**From:** Craig Dalton <Craig.Dalton@hnehealth.nsw.gov.au>  
**Sent:** Monday, 29 May 2017 11:14 AM  
**To:** Steve O'Donoghue  
**Cc:** Peter Falkiner  
**Subject:** FW: Narrabri Gas Project (SSD 6456)

Please find below the Health response to SSD 6456, Narrabri Gas Project.

I refer to the Environmental Impact Statement for the proposed development of a gas production field by Santos NSW (Eastern) Pty Ltd at Leewood, 20km southwest of Narrabri, New South Wales (NSW). The proposed development seeks to develop and operate a gas field requiring the installation of 850 wells, gas and water gathering systems and supporting infrastructure in the Pilliga area.

Non-routine operations – Power supply Option 2 (power sourced from the national electricity grid)

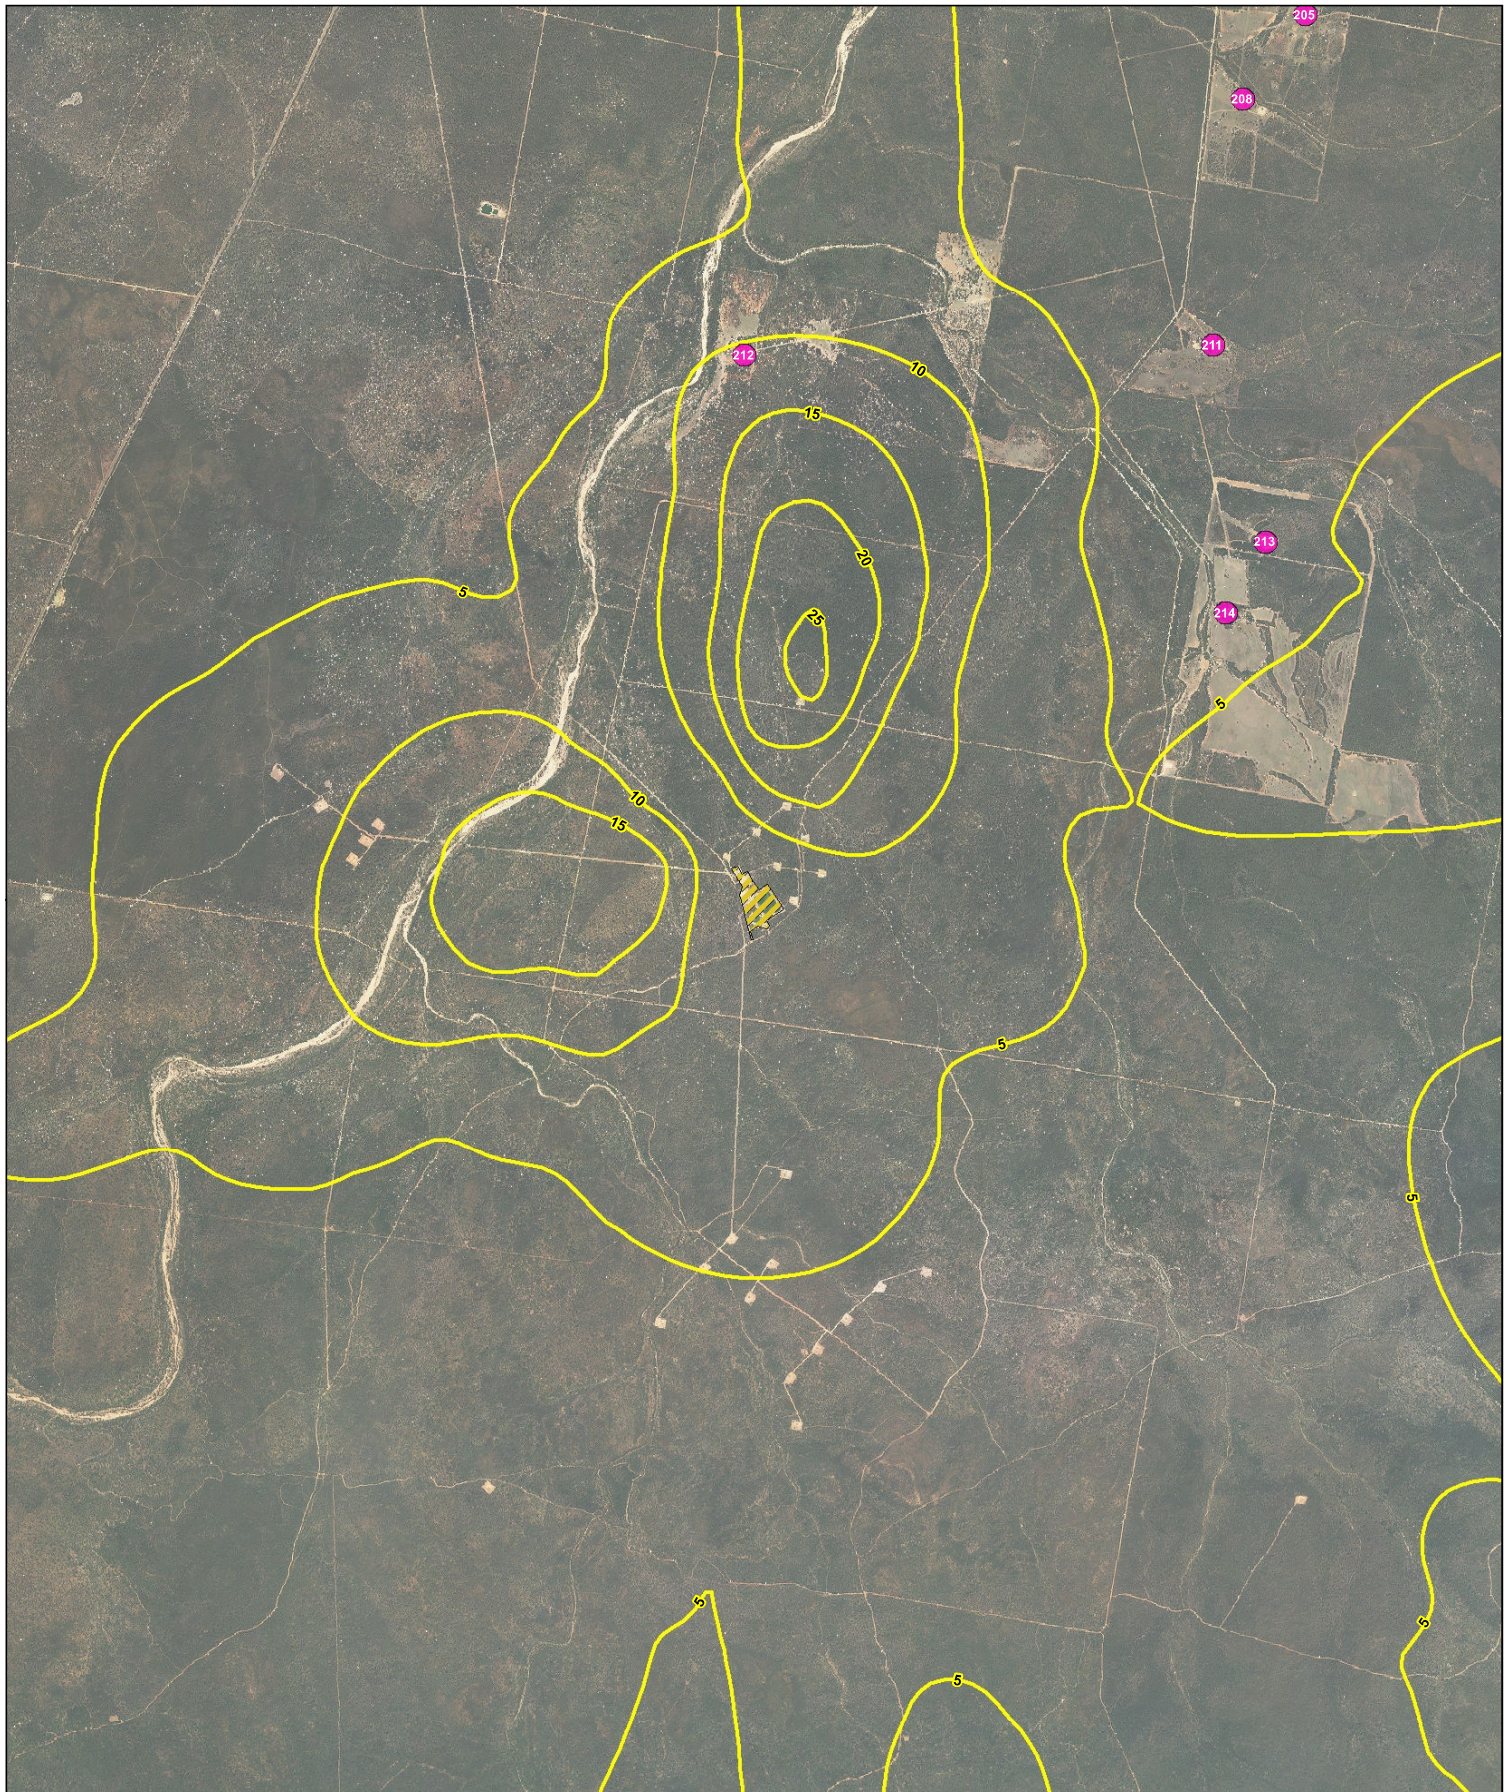
The EIS states that assessment criteria for all key pollutants will be met outside the boundary but the assessments are not shown. Air concentration contours are shown only for short term NO<sub>2</sub> and a graph displays concentration/distance for short term PM<sub>10</sub>. It will be important to show modelled contours of the air pollutants in relation to receptors (as is usually done for mine sites). Air concentration contours for annual PM<sub>2.5</sub> will be of particular interest to those concerned about health. Predicted concentrations of air toxics at receptors will also be of interest.
